DESIGNER'S RESPONSE

Road Safety Audit Stage 1

Crossley Lane, Dalton, Kirklees - Road Safety Audit Stage 1

2021-10 Dalton RSA1 – Revision 0

TITLE		FLOOD EXCEEDANCE ROUTING PARCELS 4&5 SHEET 1 OF 2			
PROJECT		CROSSLEY LANE HUDDERSFIELD			
CLIENT		MINERVA WORKS DEVELOPMENTS LTD			
DRAWING STATUS		PRELIMINARY			
Scale	1:500	© A1	Date	APR 21	Drawn AT
			Chk.	MI	
Drg. No.	906/03/22/01				Rev /

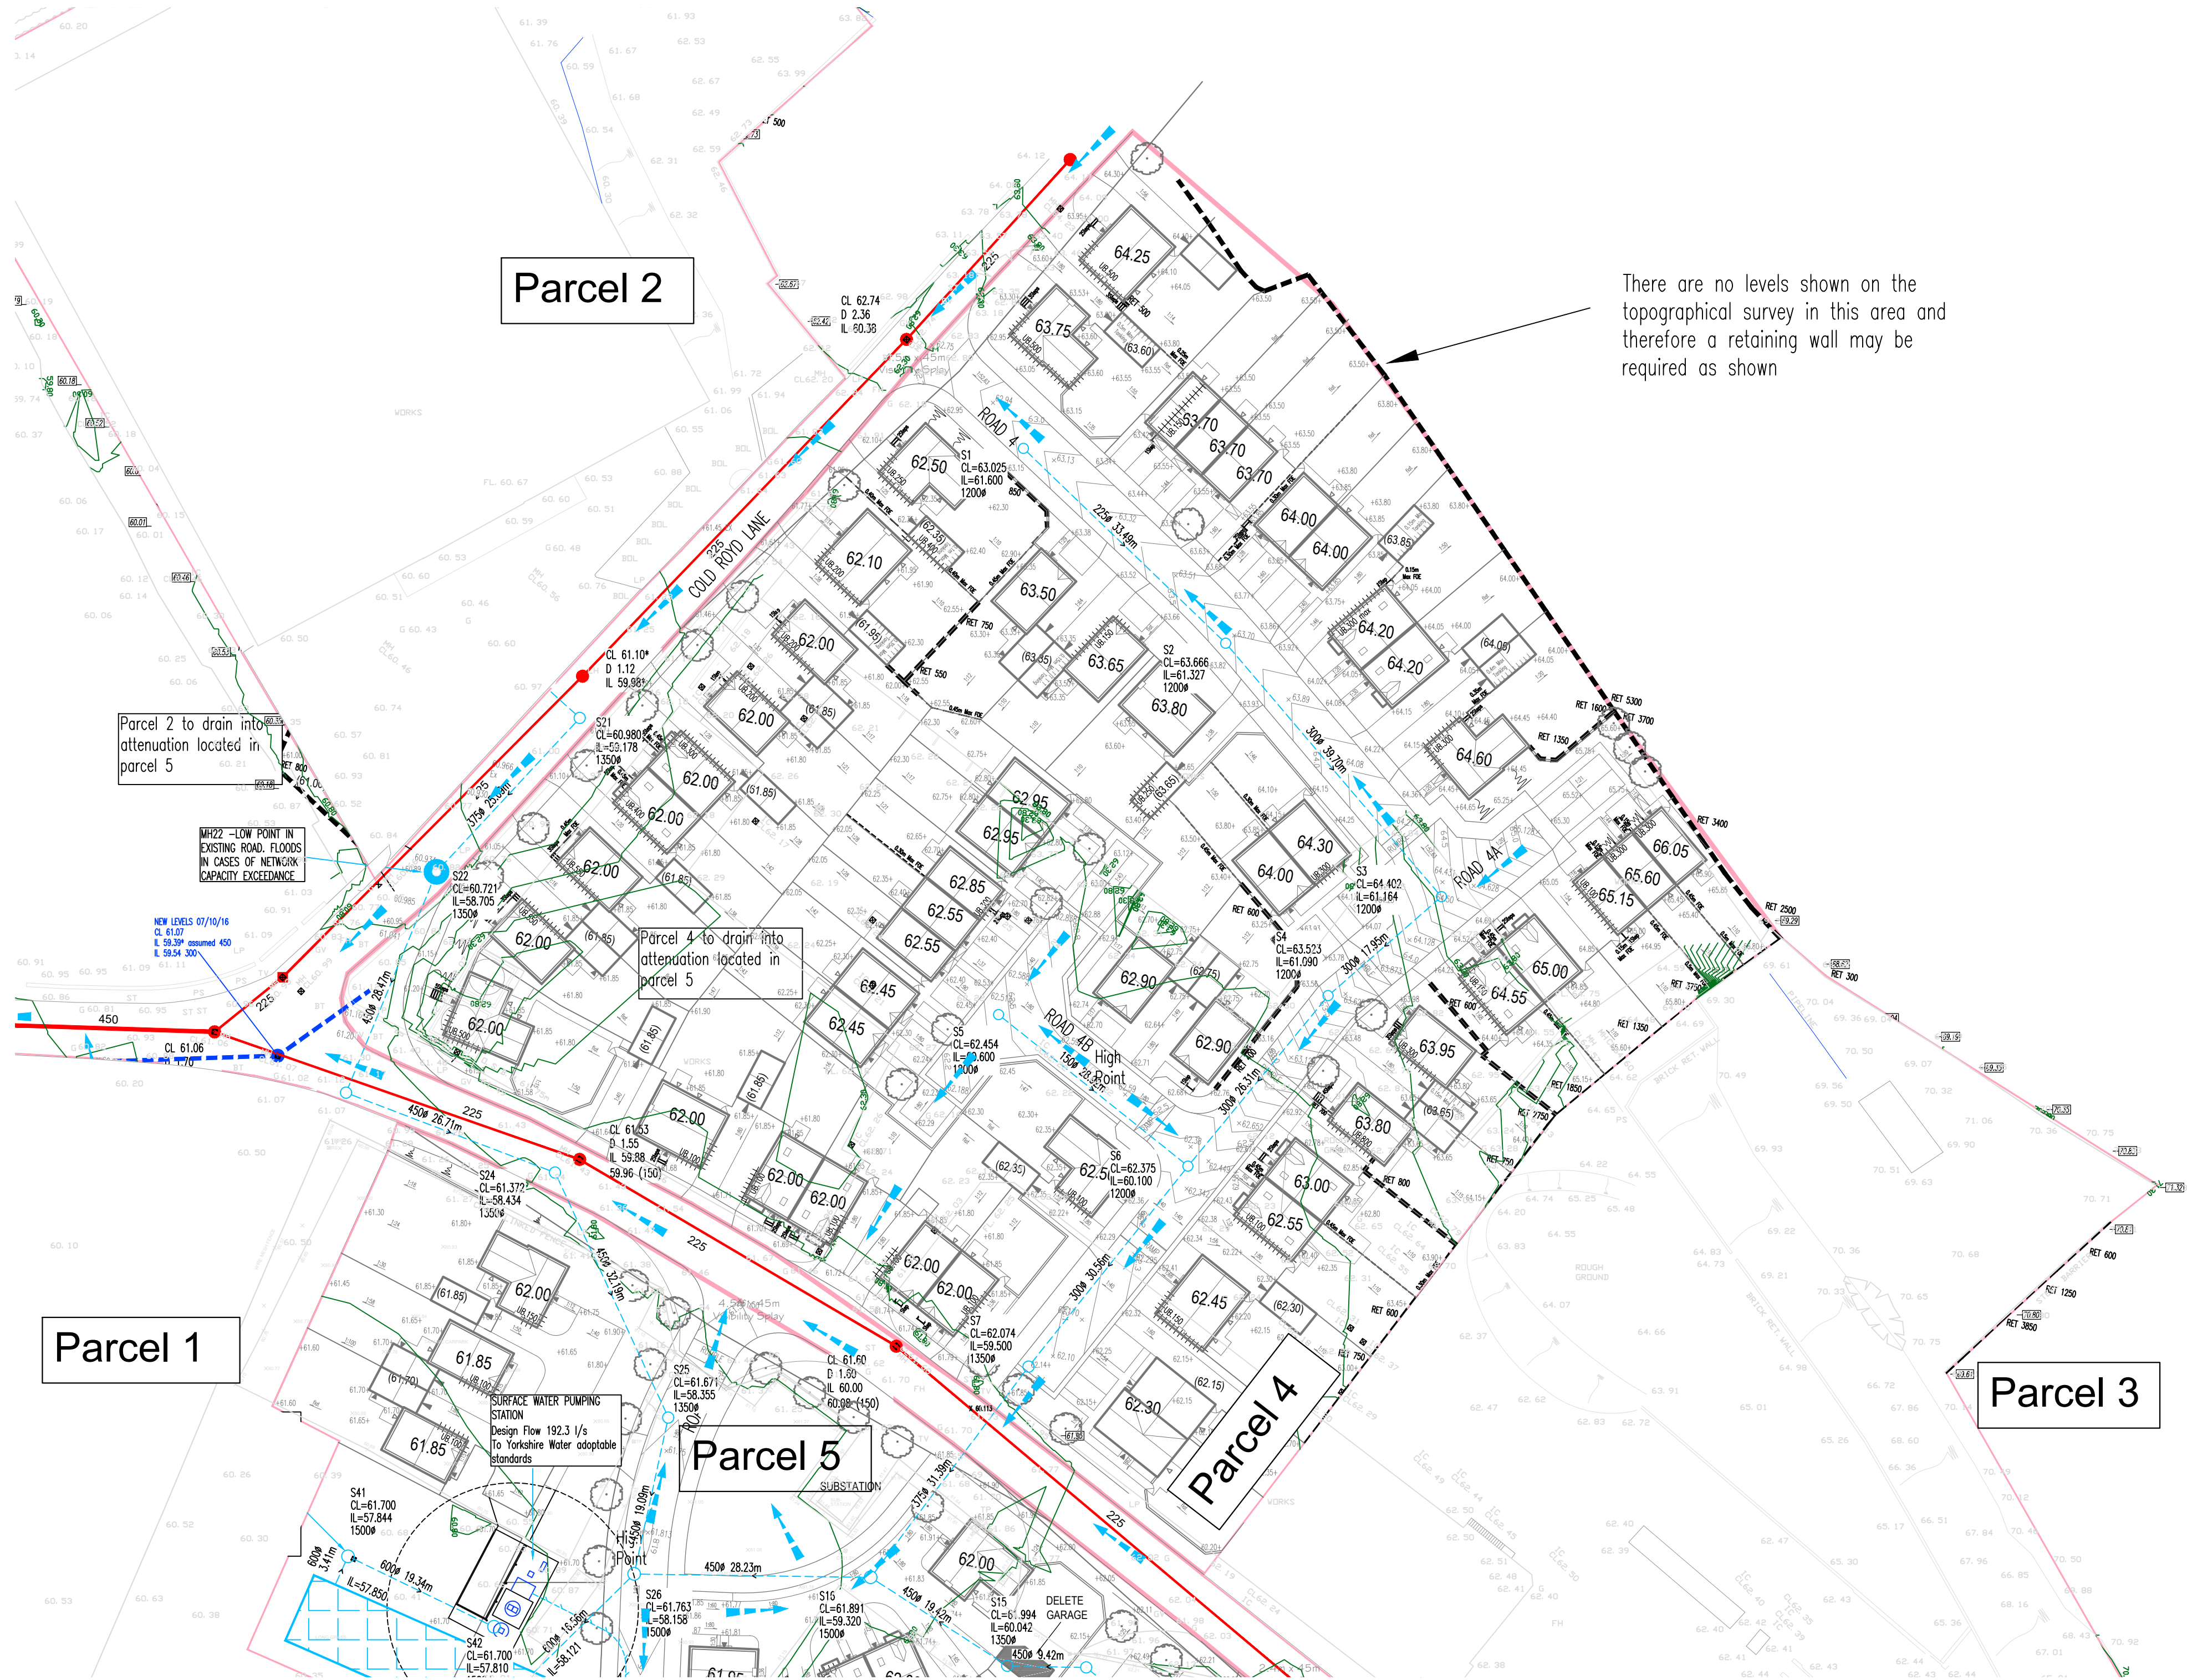
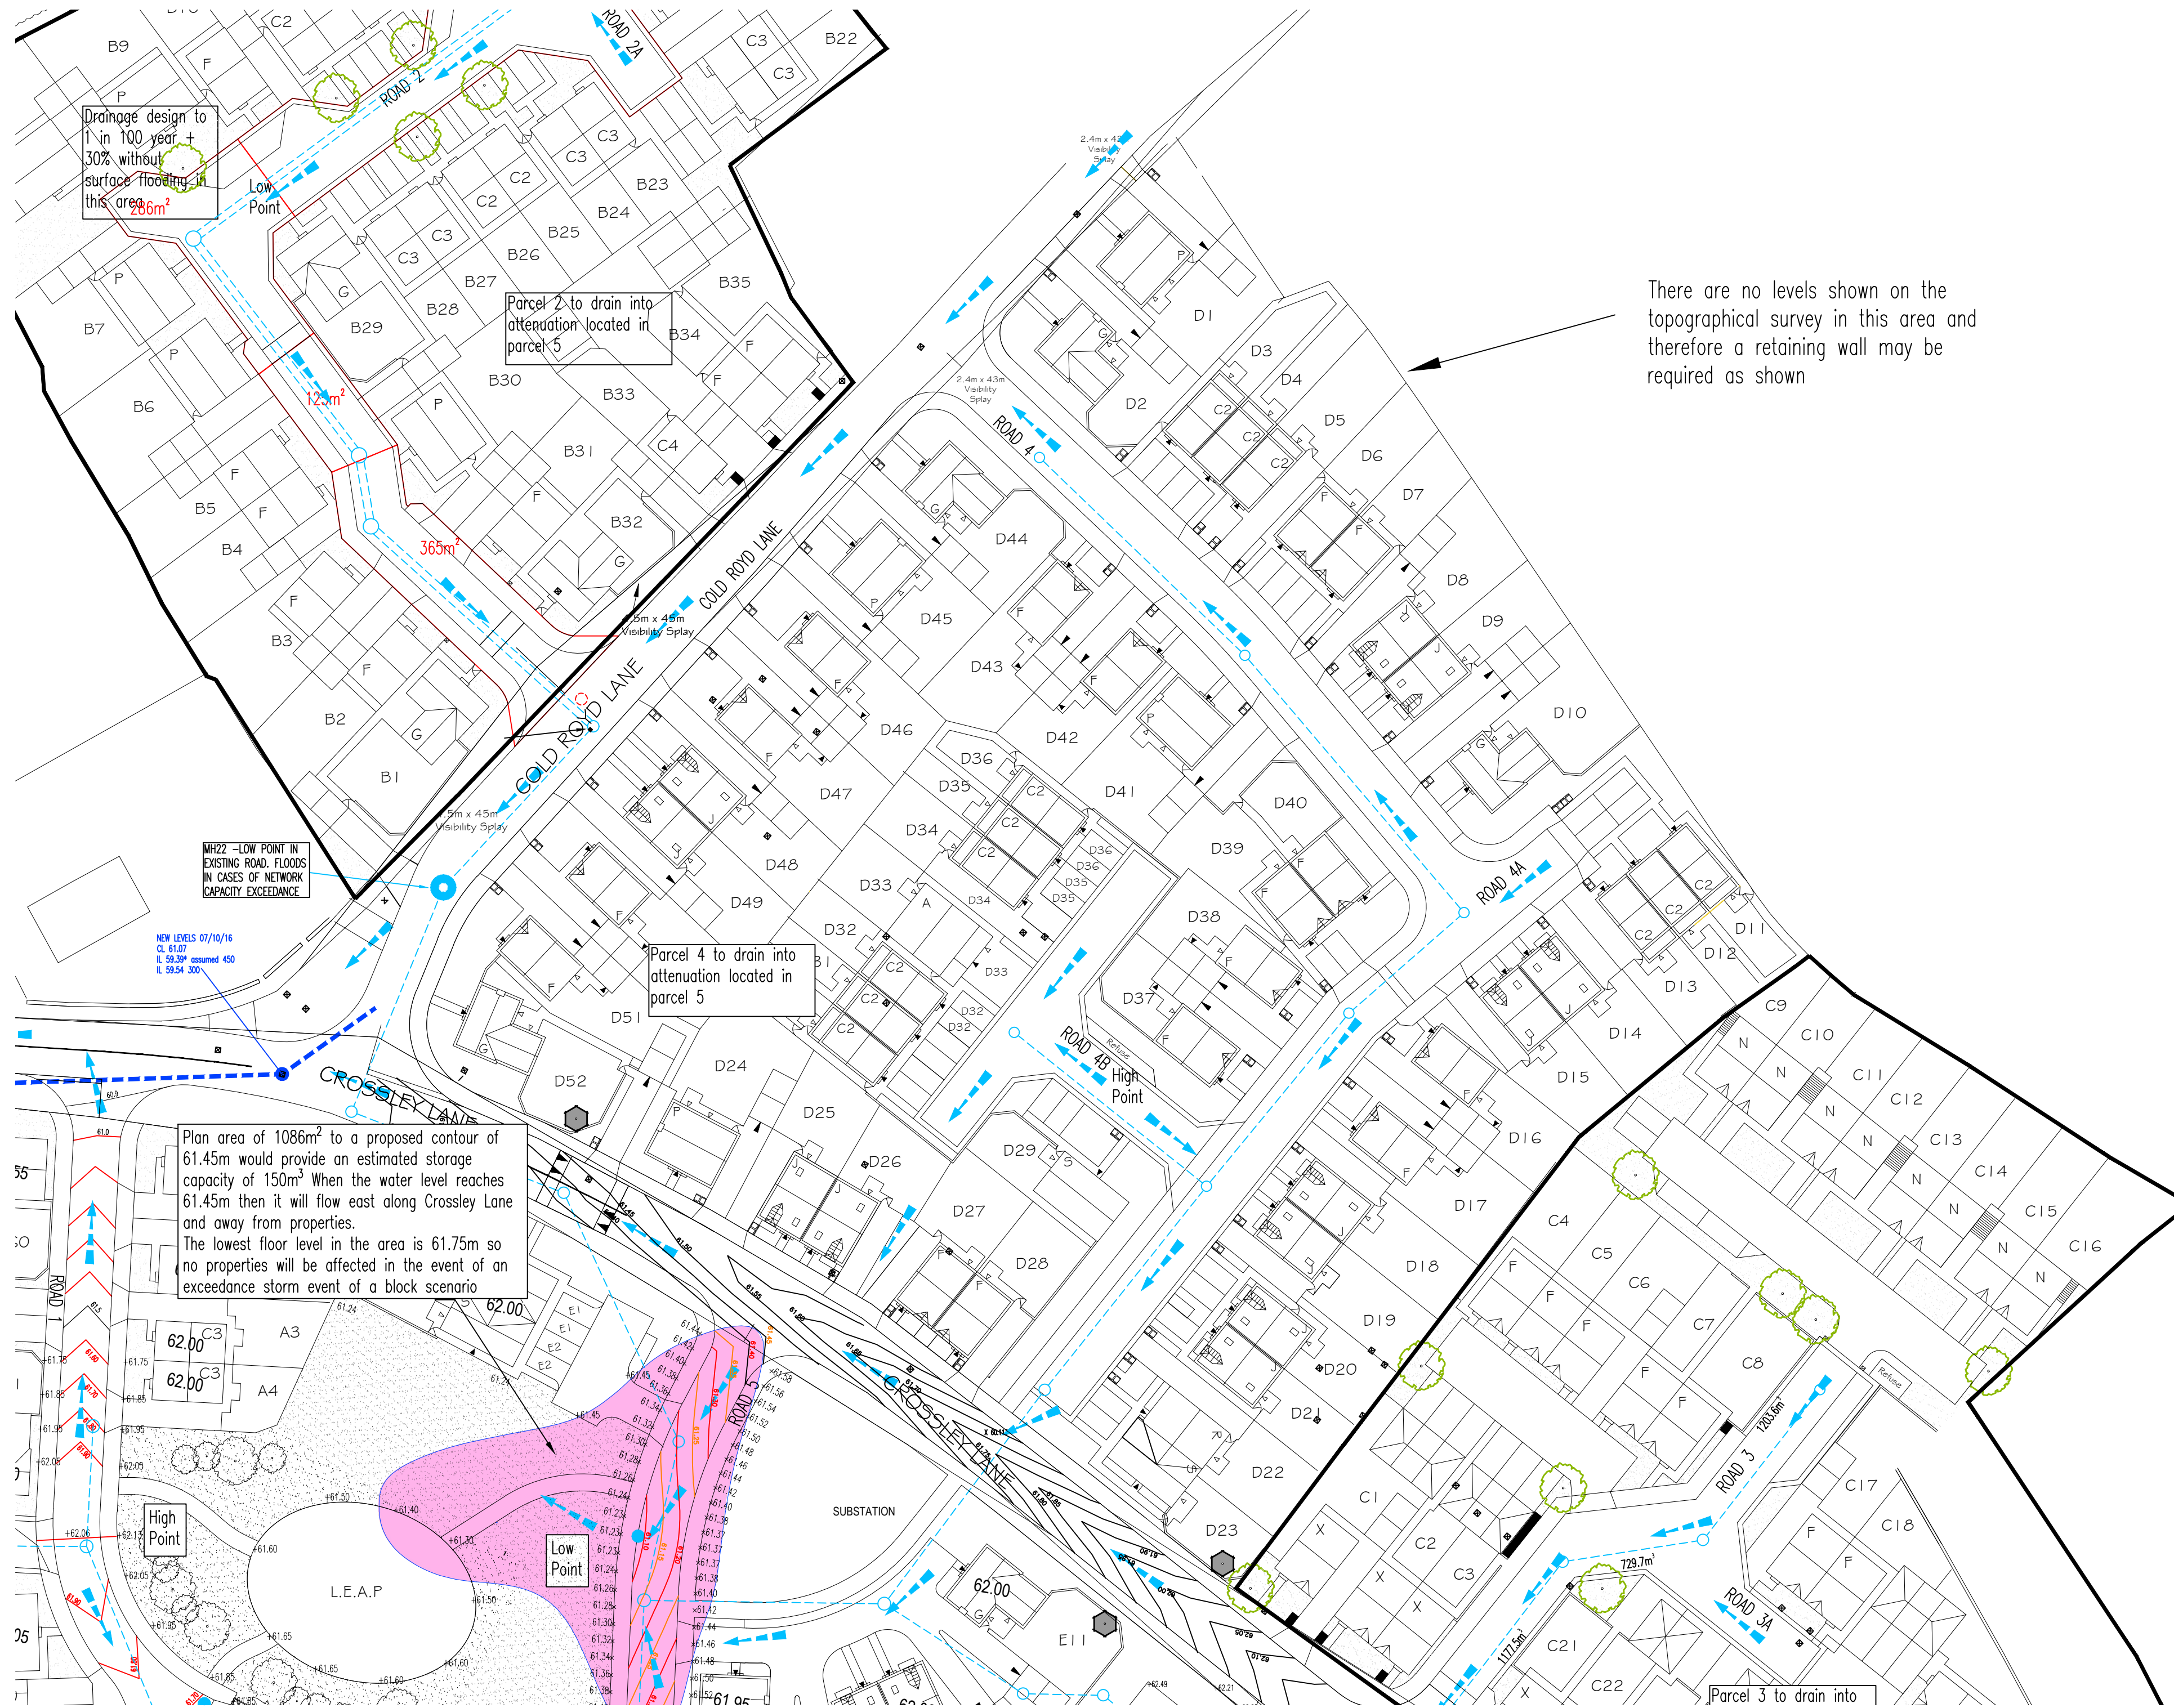
At this early stage, no details have been provided on the proposed drainage arrangements. It was noted that the development site was relatively level, as such, this may require measures to manage surface water around junction and on the internal estate roads, to reduce the risk of standing water and detritus that may consequently cause skidding type collisions or slips and falls by pedestrians crossing in this area

It is recommended that drainage details are provided at the next stage of road safety audit including locations of gully locations, levels and contours.

Accepted – full drainage proposals shall be provided as part of the detailed design as recommended.
